No.	RSA Problem	Audit Team Recommendation(s)	Design Organisation Response	Audit Team Correspondence	Overseeing Organisation Response	Agreed RSA Action
2.1	<p>Summary: Potential collisions due to standing water or service covers <i>Location: Throughout</i></p> <p>No details have been provided in respect of surface water drainage or other services and it is therefore not possible to ascertain whether or not there will be any safety implications. The absence of adequate surface water drainage may increase the risk of the collection of surface water which may contribute to the increase risk of loss of control collisions.</p>	<p>Ensure that adequate surface water drainage is provided, if necessary, provide additional drainage.</p>	<p>Details of drainage will be provided and agreed through the detailed design, technical approvals and S278 stage and the appropriate highway drainage will be provided in accordance with WSCC specification. It is not considered that there are any constraints preventing the provision of drainage in line with standards.</p>	<p>Accept</p>

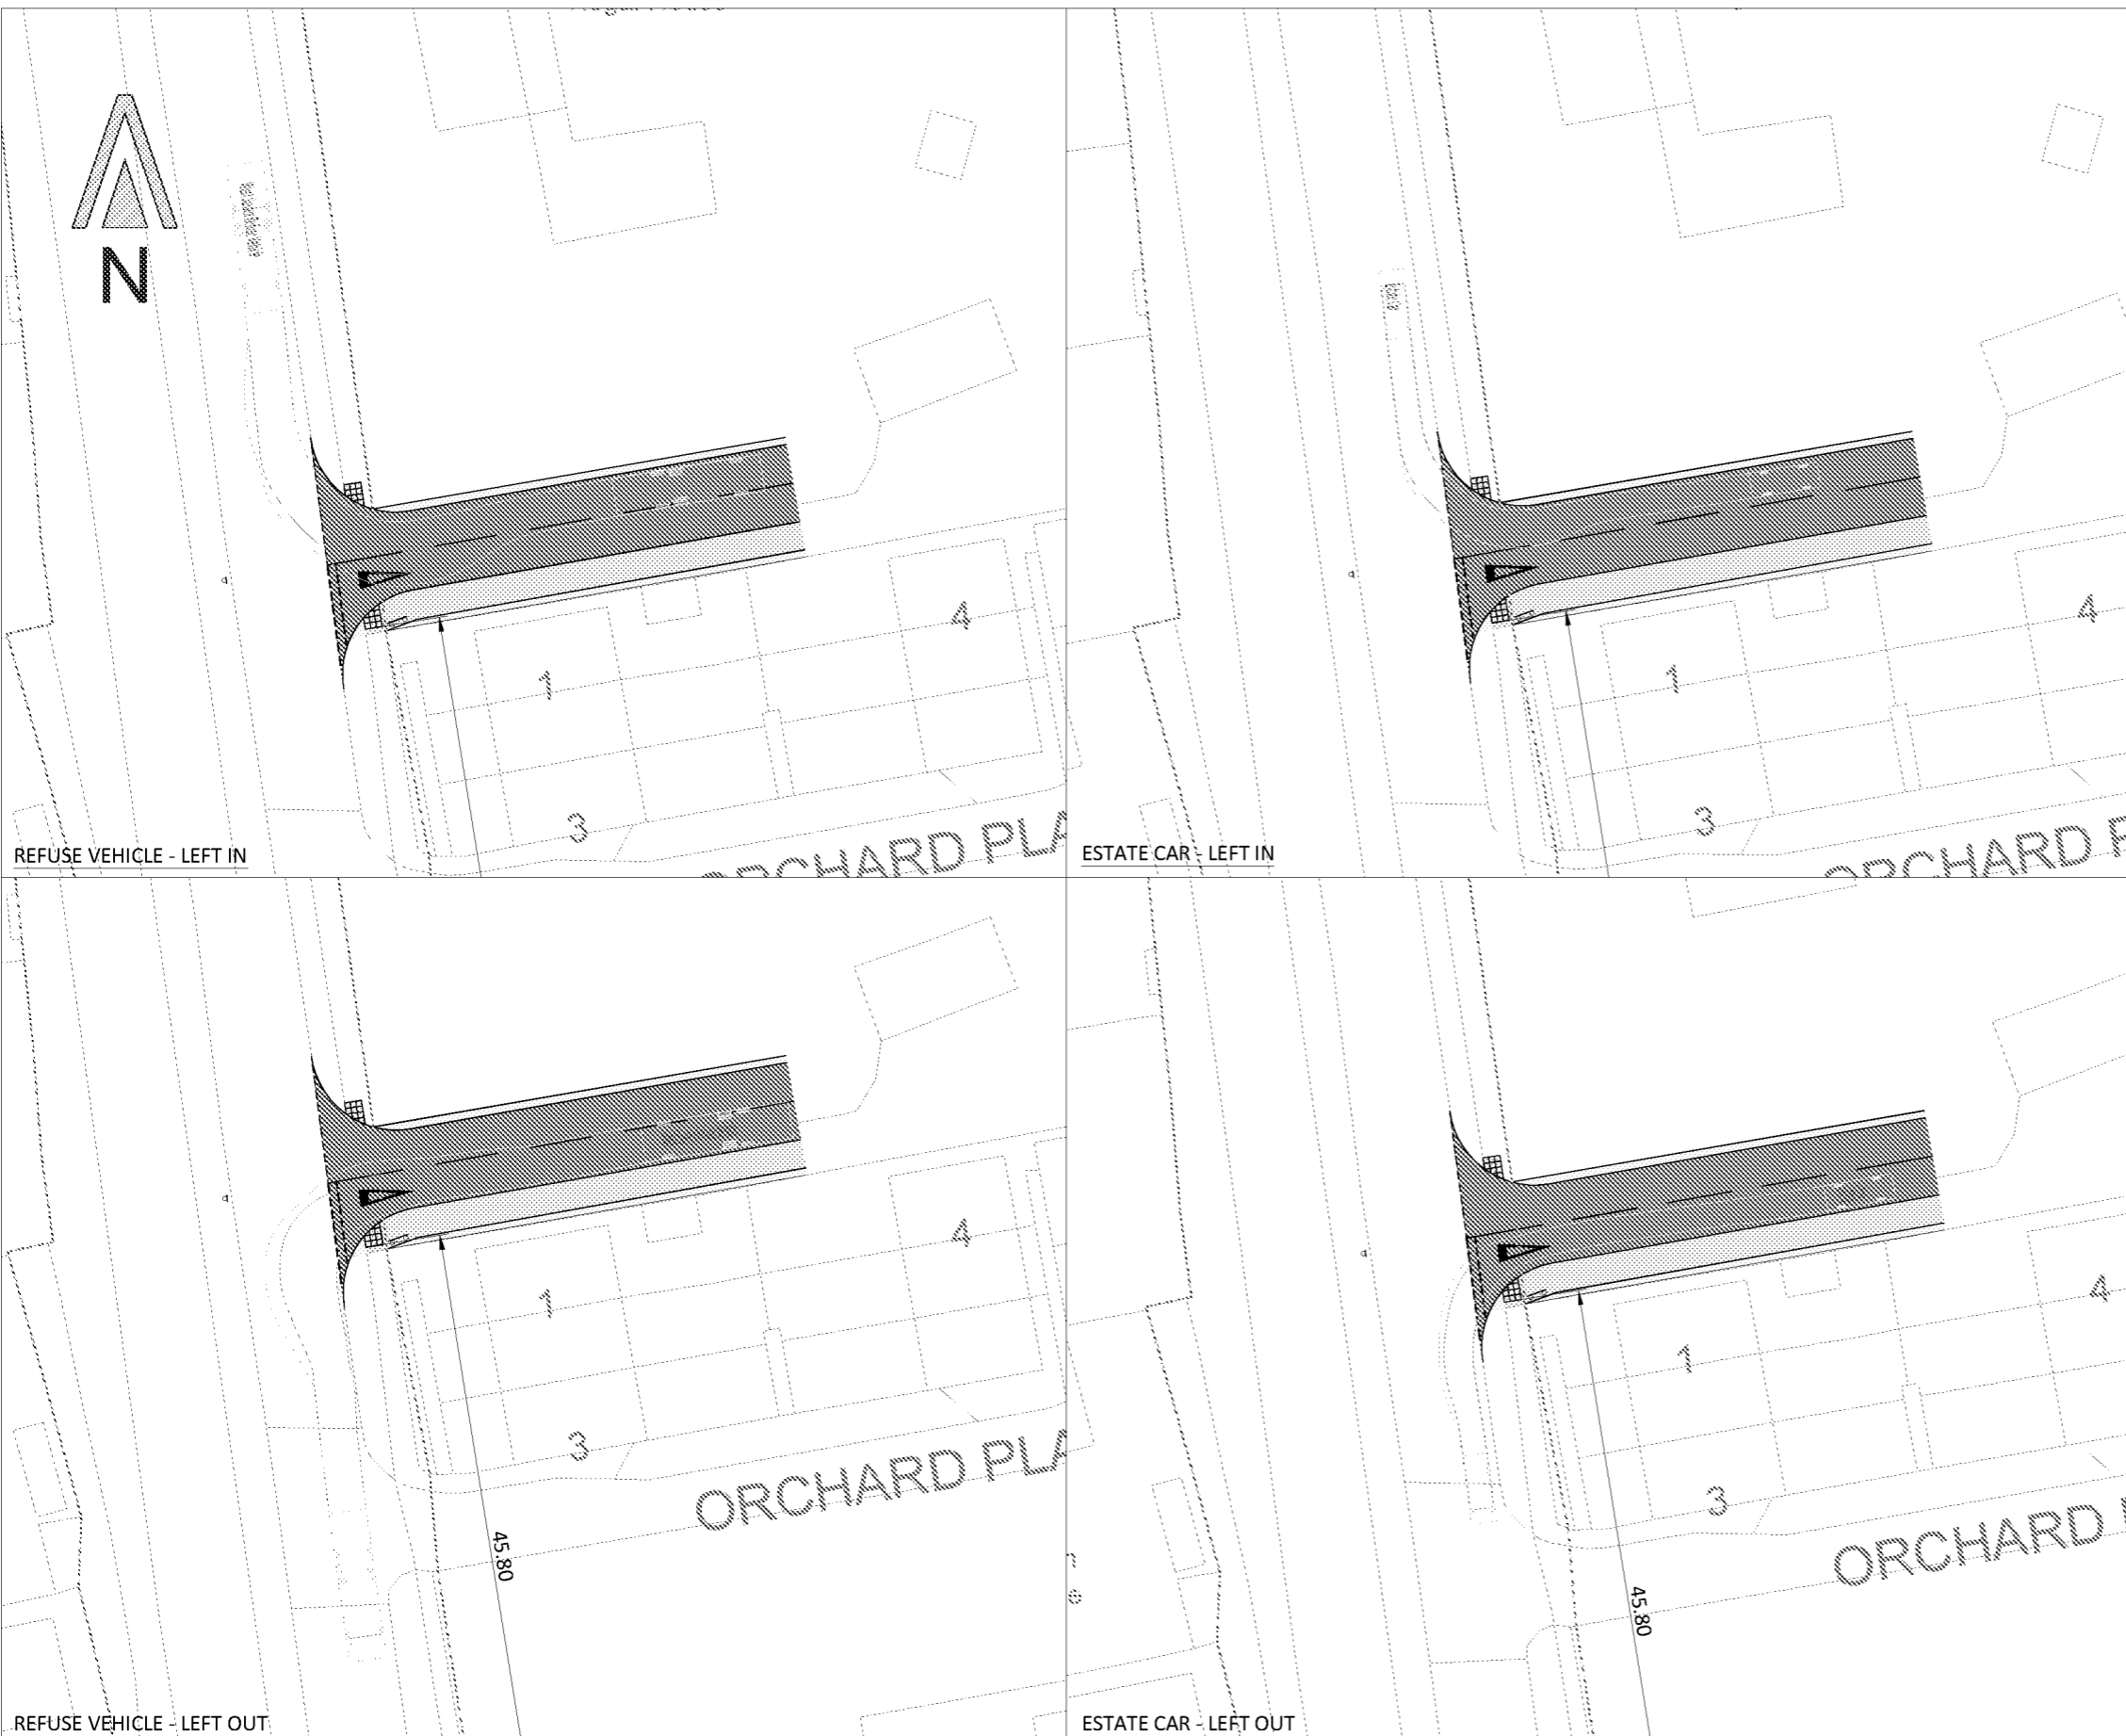
3.3	<p>Summary: Potential risk of vehicle collisions associated with obstruction in visibility <i>Location: Proposed development access</i></p> <p>The scheme drawing indicates that appropriate visibility splays to and from the development access can be achieved. However, vegetation/landscaping behind the visibility splay may over time restrict visibility for vehicles waiting to turn out of the development. Poor visibility may increase the risk of vehicular collisions between traffic turning out of the site and vehicles travelling south along A29 Shripney Road.</p>	<p>Ensure that any vegetation/landscaping behind the visibility splays is cut back and regularly maintained, or of a low-level variety.</p>	<p>Drawing R-21-0021-001.B demonstrates that a visibility splay of 2.4m x 120m is achievable to the north in accordance with DMRB guidance for a 40mph road. It is noted that the verge on the eastern side of A29 Shripney Road is provided fully within the highway boundary. As such, any vegetation and landscaping within the visibility splays can be cut back and maintained by the Local Highway Authority as required.</p>	<p>Accept</p>

Appendix D – Proposed Pedestrian Crossing

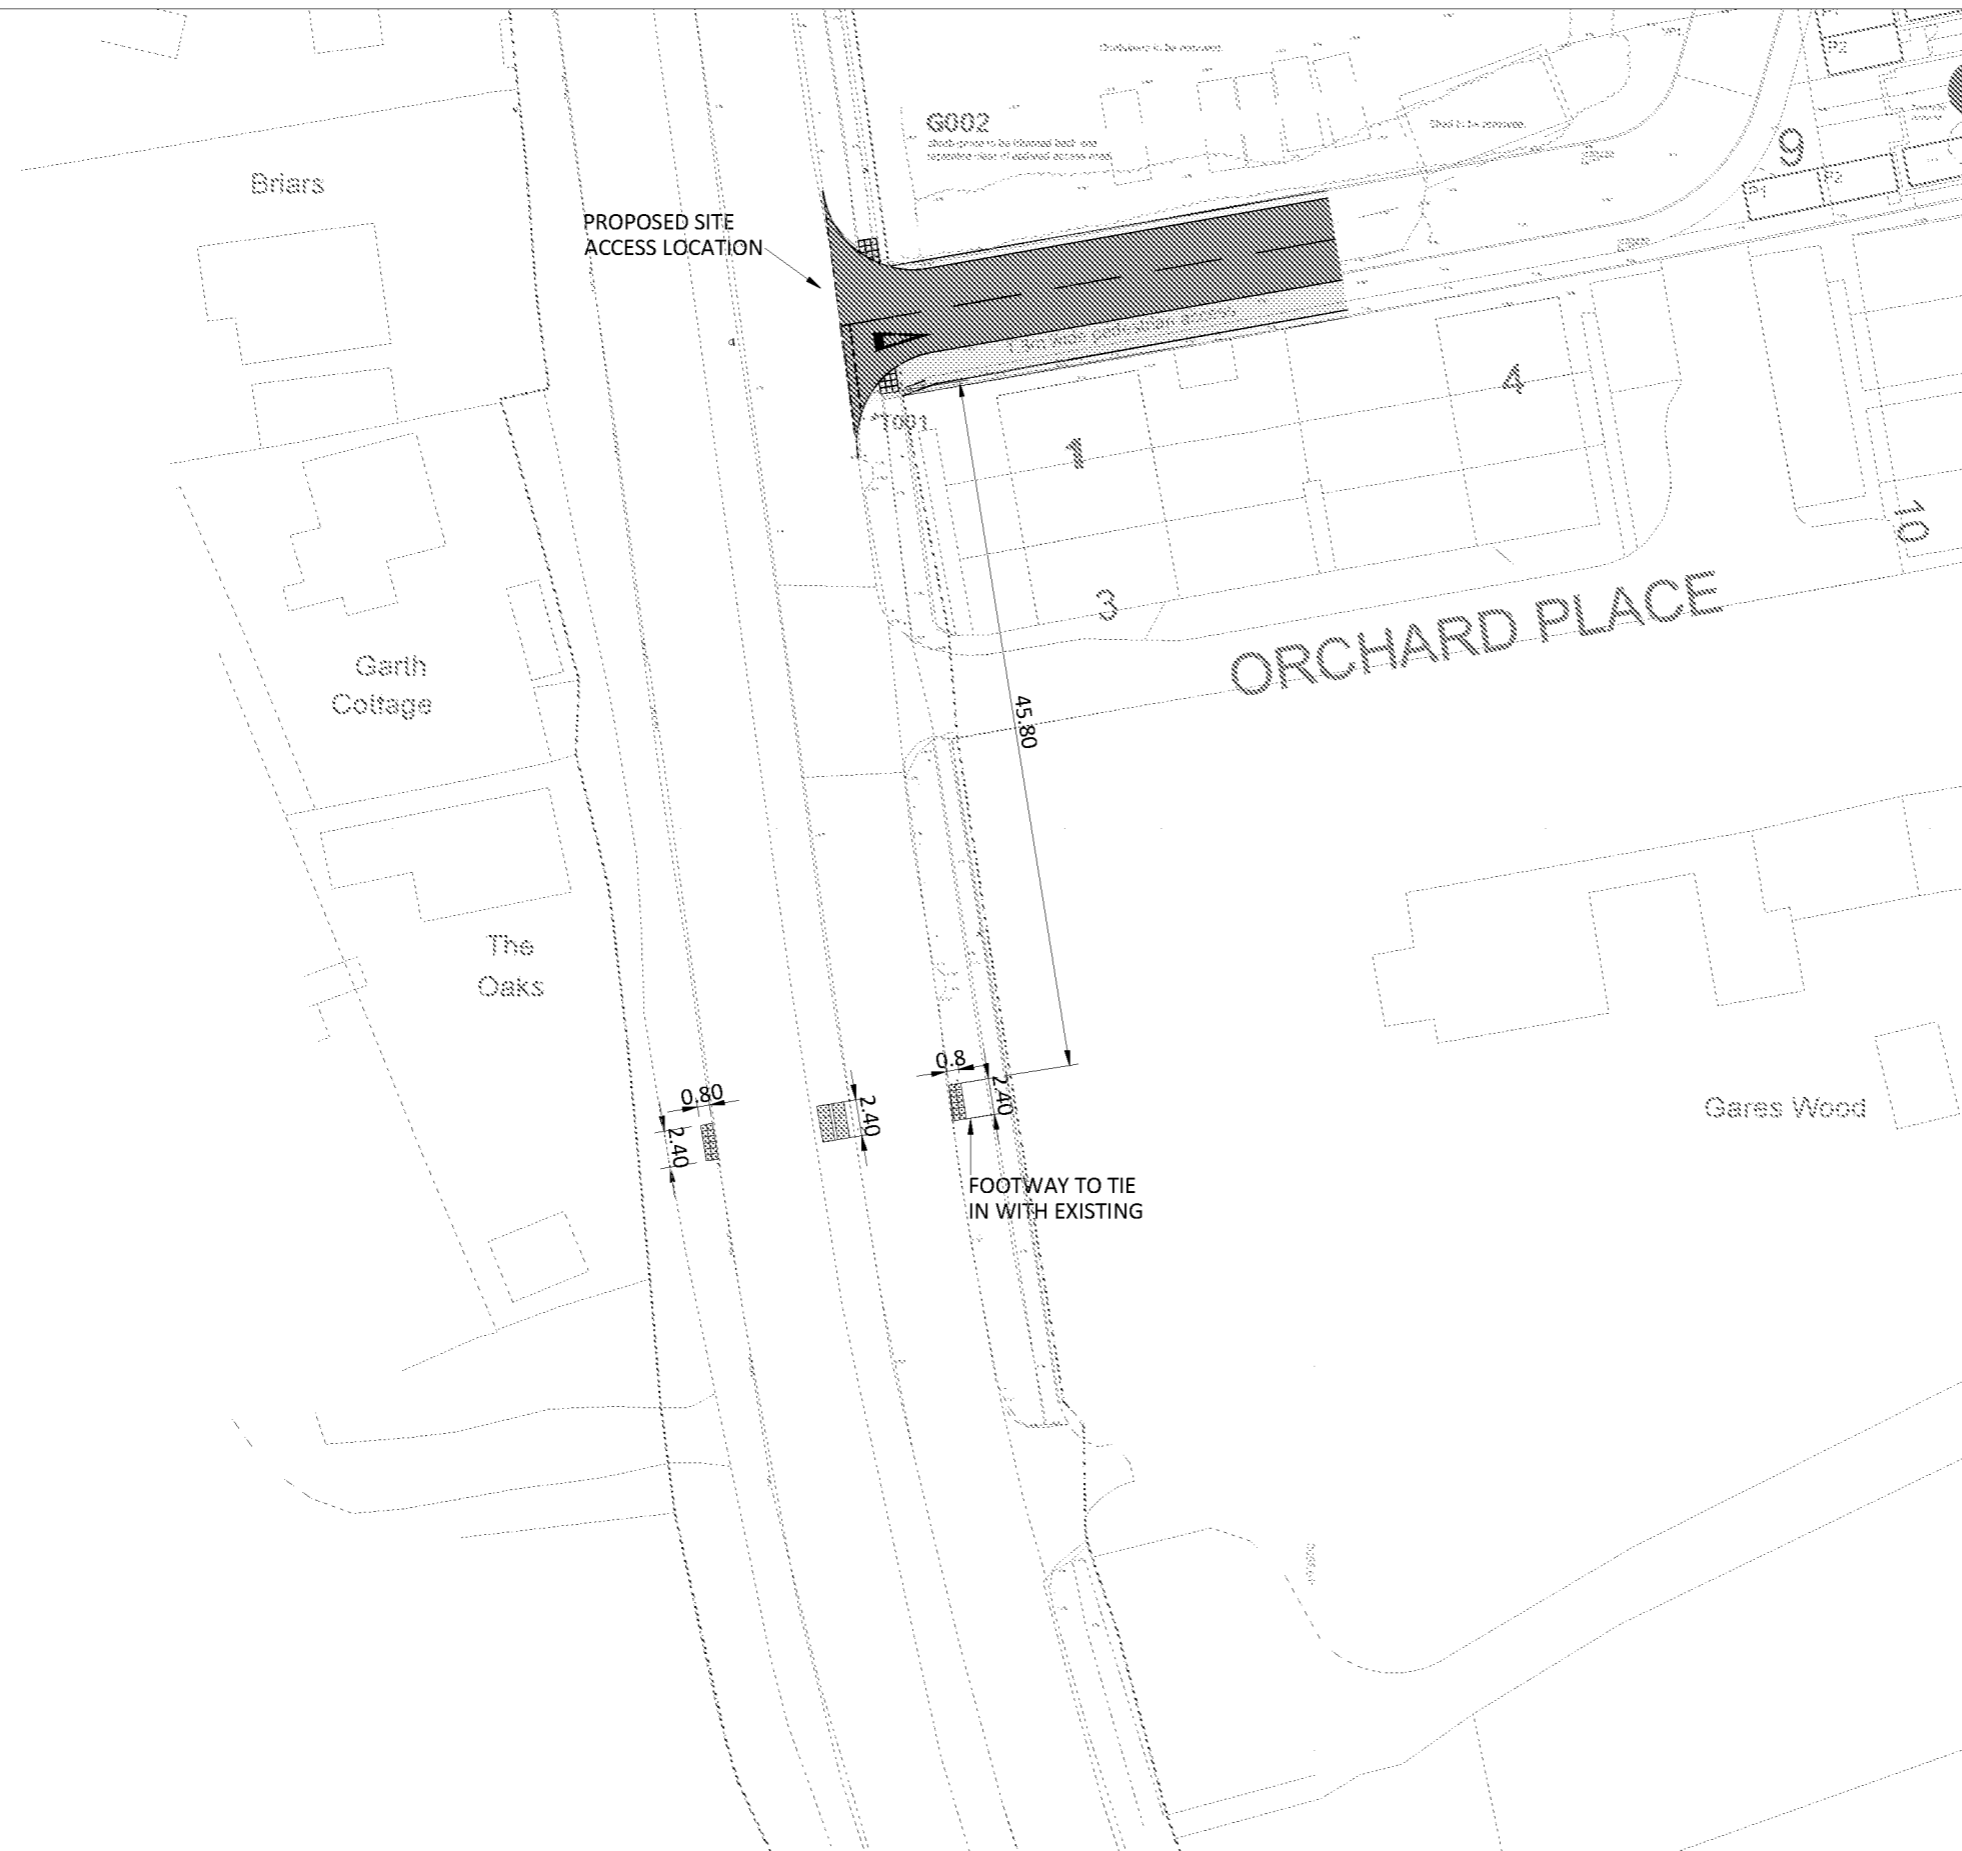
4.1	<p>Summary: Potential risk collisions associated with layout of crossing and obstruction in visibility <i>Location: Uncontrolled pedestrian crossing facility across A29 Shripney Road</i></p> <p>The scheme drawing indicates a proposed uncontrolled pedestrian crossing facility across A29 Shripney Road. However, there is concern that the introduction of the refuge island within the central median is unconventional, in addition the footway fronting the development to the crossing point is narrow and whilst visibility splays to the crossing can be achieved, the dense vegetation within the central median may restrict visibility to the north for pedestrians waiting to cross the A29.</p>	<p>The central refuge island should be removed and replaced with a conventional uncontrolled crossing facility ensuring that any vegetation within the central median is cut back to improve visibility to and from the crossing.</p>	<p>The central refuge island shown in Drawing R-21-0021-003 has been removed and Drawing R-21-0021-003.A replaces the previous version of the drawing and shows a revised pedestrian crossing proposal with the provision of tactile paving on the central median. Vegetation on the central median within the pedestrian visibility splays shown in Drawing R-21-0021-004.A can be cut back and maintained by the Local Highway Authority as this lies within the highway boundary. This will ensure that pedestrians waiting to cross will be seen by vehicles and vehicles travelling along Shripney Road will also be seen by pedestrians.</p>	Accept
